Engineers Comments Regarding Surface Water Drainage

APPLICATION NO: WA/86/19/PL

Site Address: Walberton Baptist Church The Street Walberton BN18 0PG

Description of Works: Application for variation of condition imposed on planning reference WA/54/17/PL relating to condition No.4 - alternative surface water drainage scheme - This application may affect the character & appearance of the Walberton Village Conservation Area.

PROPOSED GROUND FLOOR PLAN

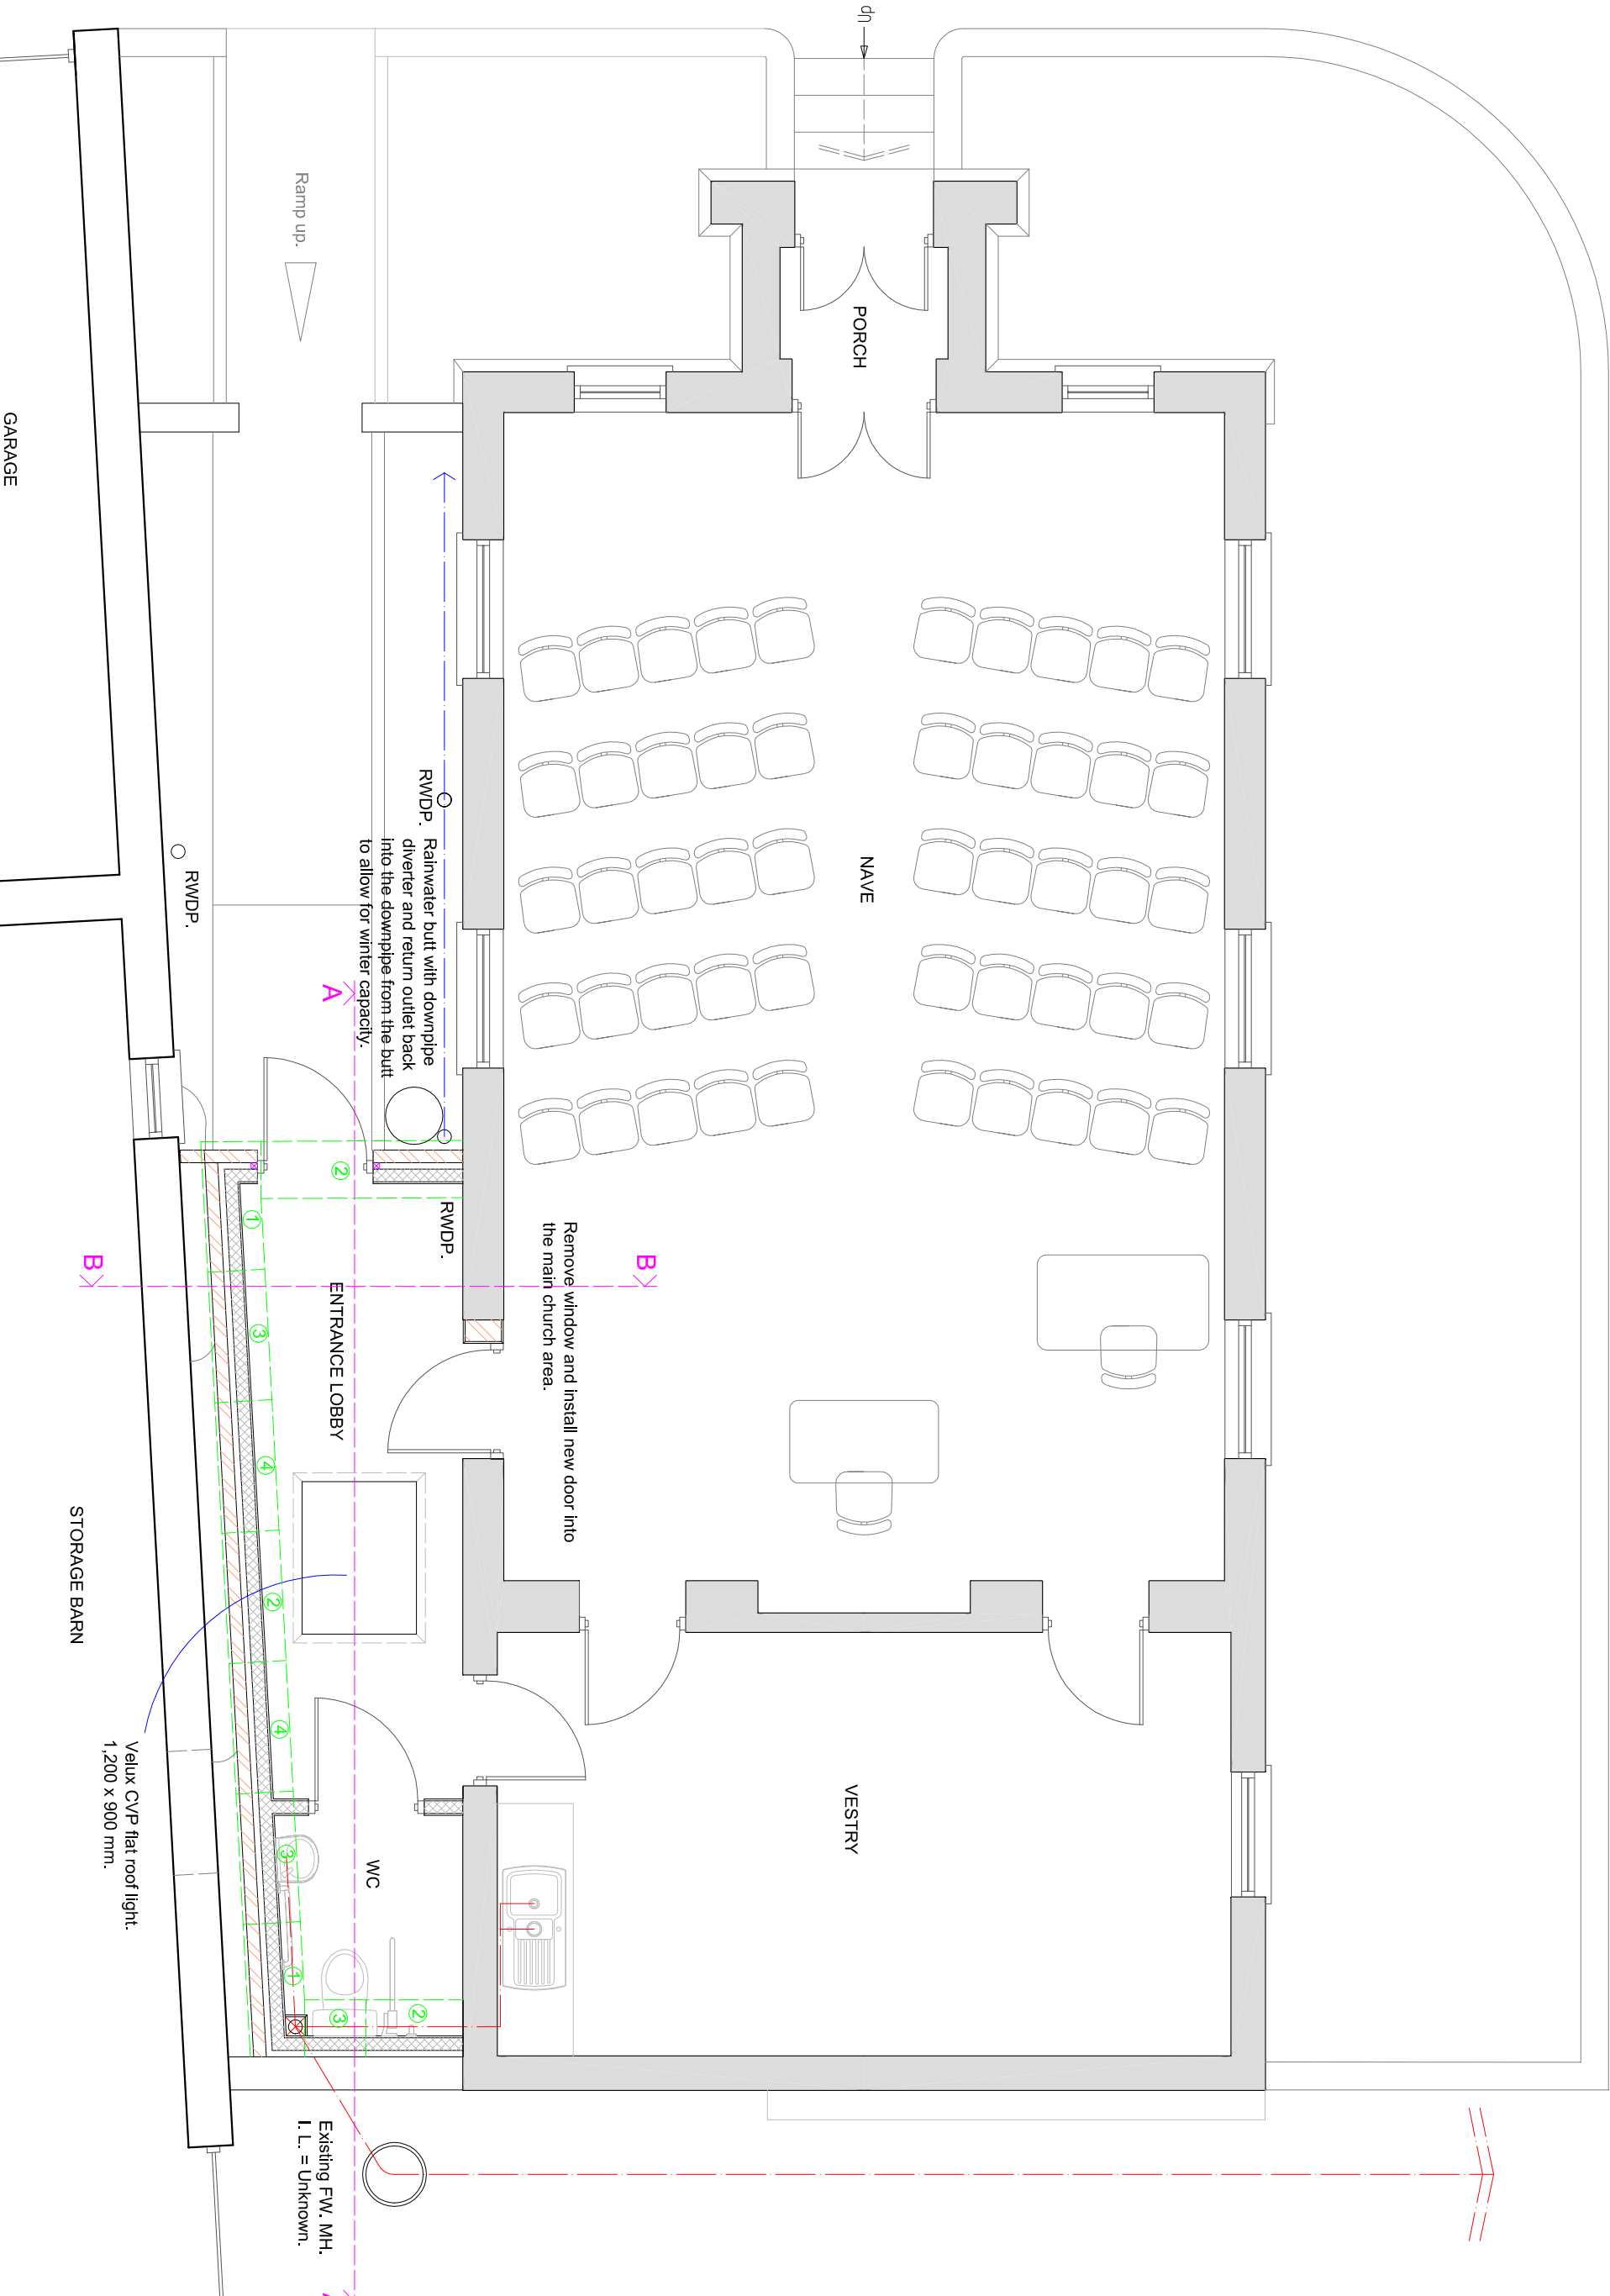
Having met with the applicant on site it is considered that the proposed drainage strategy is the only solution and that it will not increase flood risk. The proposed rainwater butt should result in betterment over the current situation.

Please condition drainage so that it is built in accordance with the proposed ground floor plan (rev D) and the extension detail plan of the rainwater butt.
